**RE: Application Reference: 2012/1054 – Residential development of 41No.
Dwellings at Higham Lane, Dodworth.**

Following a meeting to review the consultation comments on 08th November 2012 with David Connole – Redrow Homes, Mark Johnson - Dacres and Andrew Burton, Barbara Wilson, Wayne Atkins and Nik King – Barnsley Metropolitan Borough Council please find enclosed amended/ additional information to assist with the above planning application.

We have summarised all comments from the highway officer, drainage officer and urban design officer below along with Redrows response.

Development	Higham Lane
Location	Dordworth
Marketing Name	
Drawing Title	Boundary Treatment
Drawing Number	4707-16-02-02
Revision	A
Scale @ A2	1:500
Drawn By	CU
Checked by	
Date	28.08.12

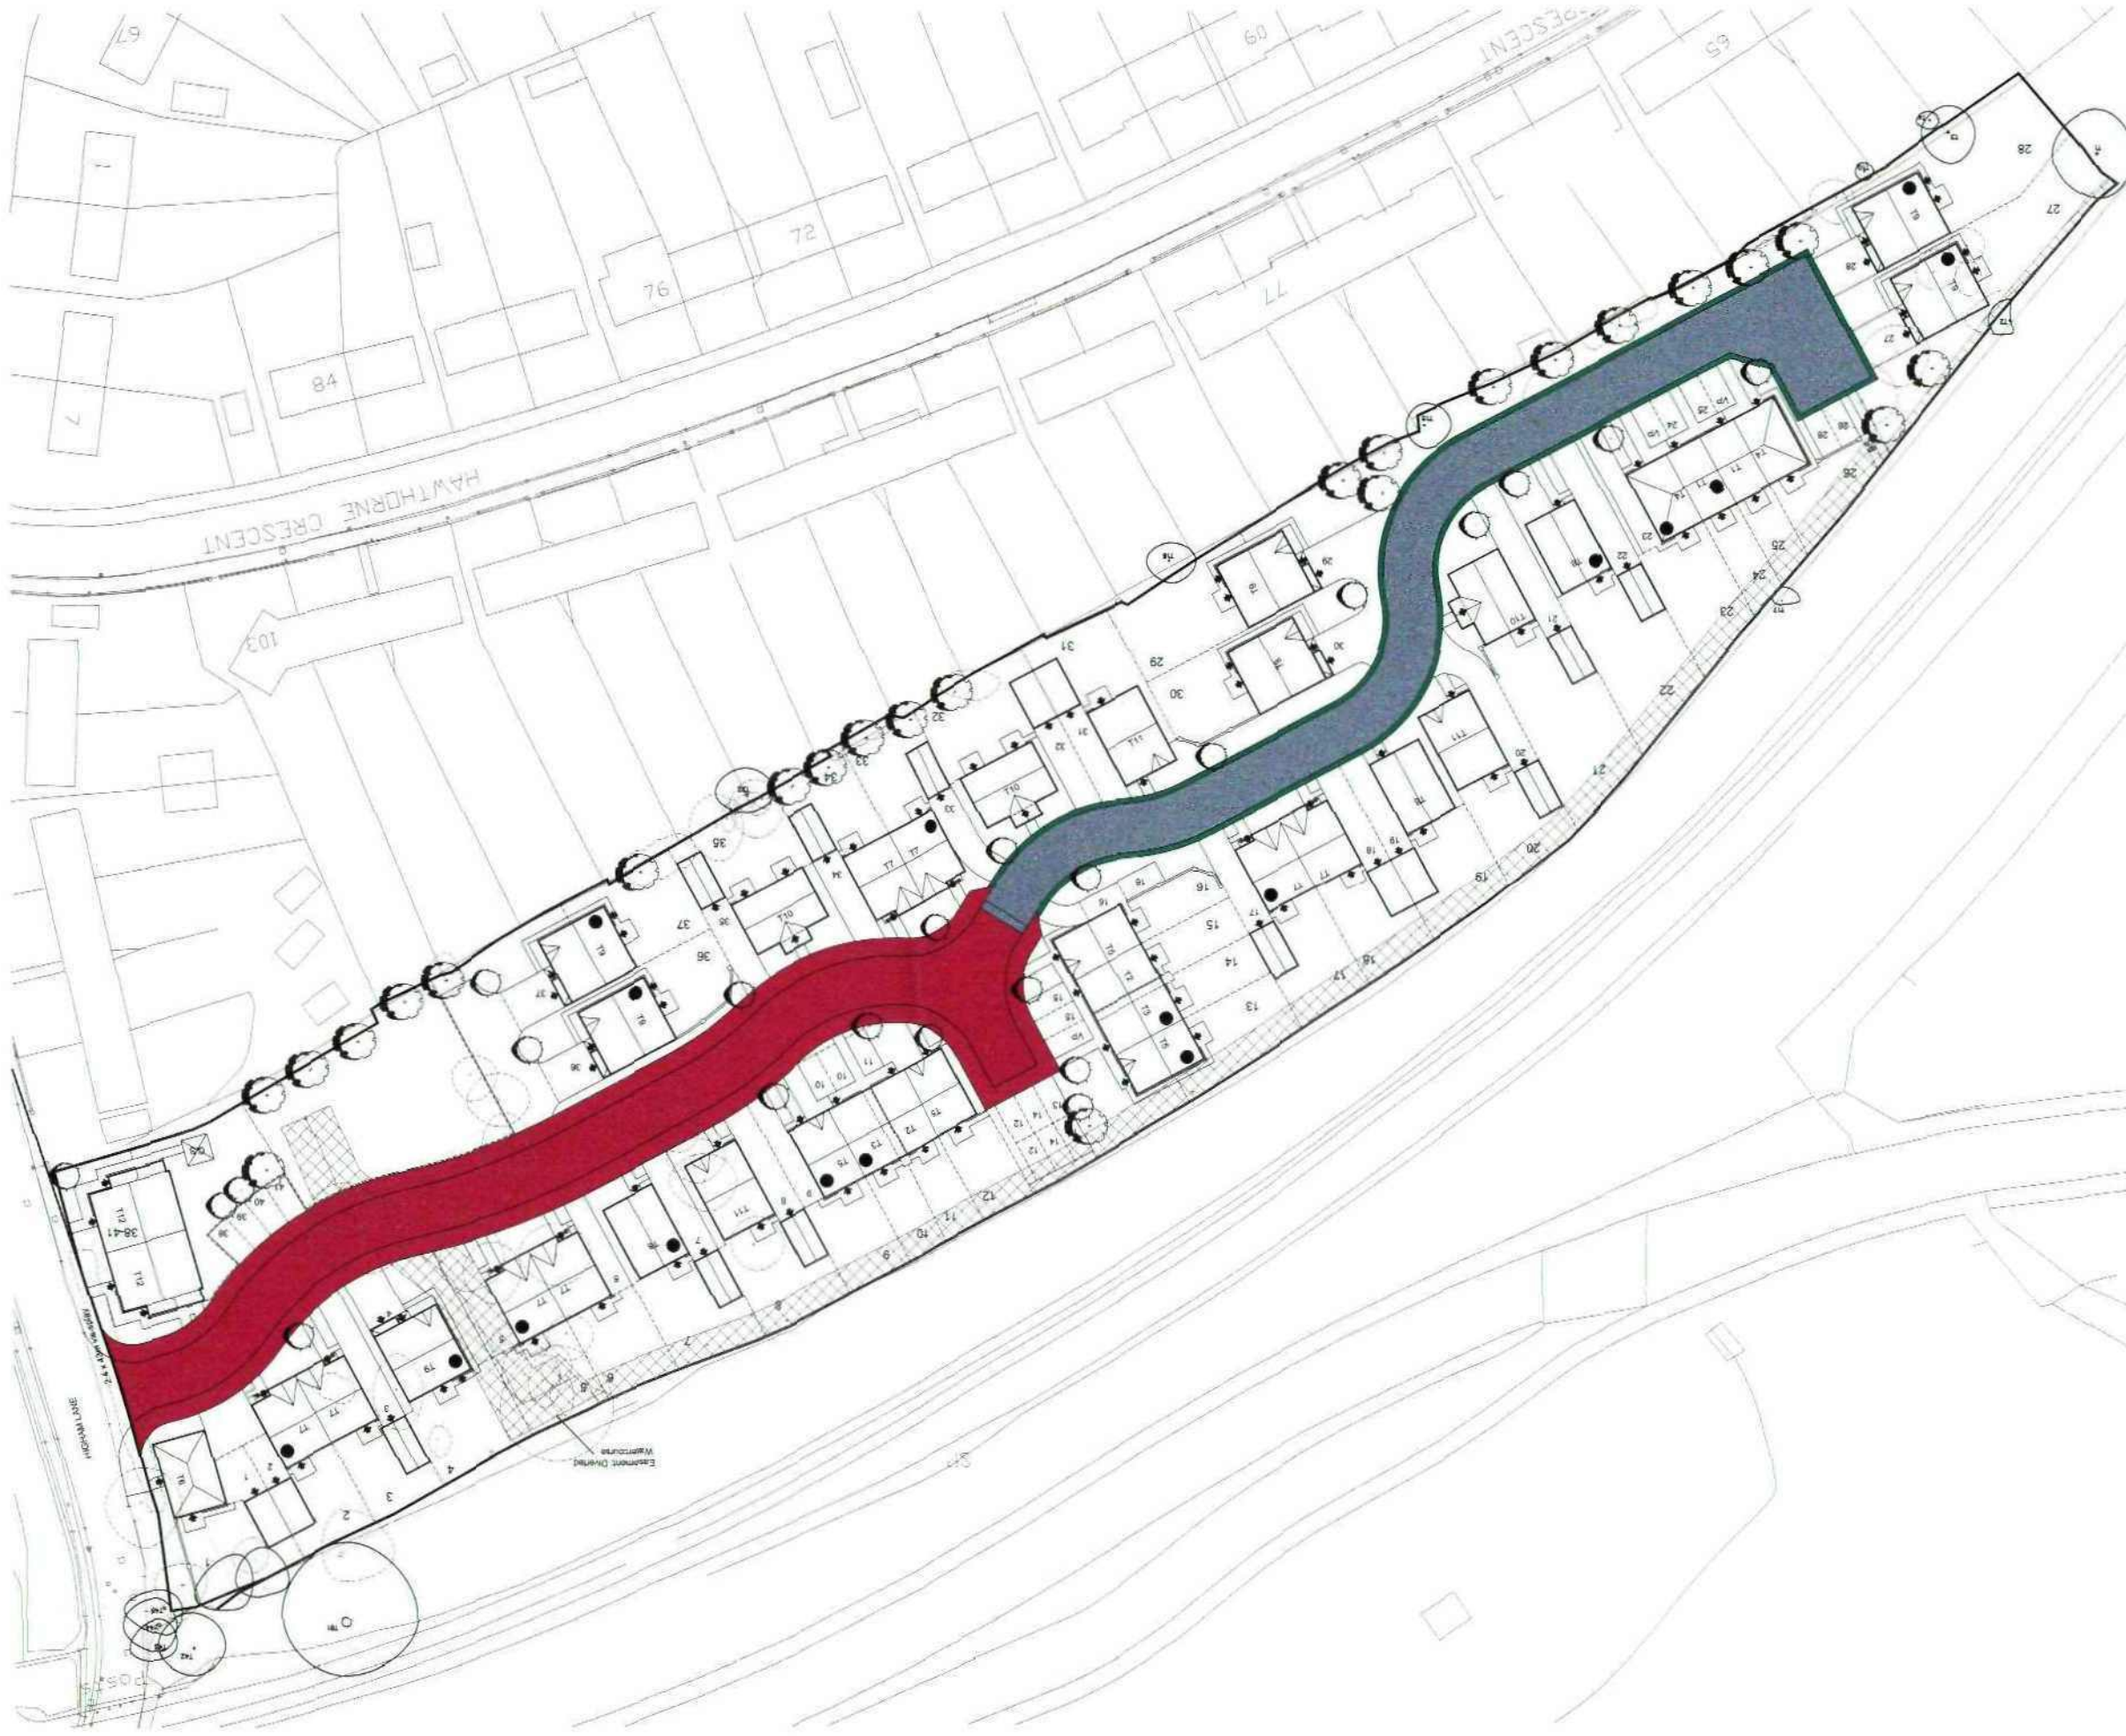
Additional rear boundary treatment to be shown to plots 38-41. The edge of the open space and car parking spaces could do with a knee rail boundary to prevent rogue car parking.

- Drawing 4707-16-02-02A has been revised to include additional boundary treatments to plots 38-41 and to the edge of the open space and car parking spaces as requested.

A gate is required at the front of the ginnels to make them secure.

- Drawings 4707-16-02-02A and 4707-16-02-05A have been revised to show that access to the rear gardens through the ginnels (plots 10-11 and 14-15 only) are through lockable gates as requested.
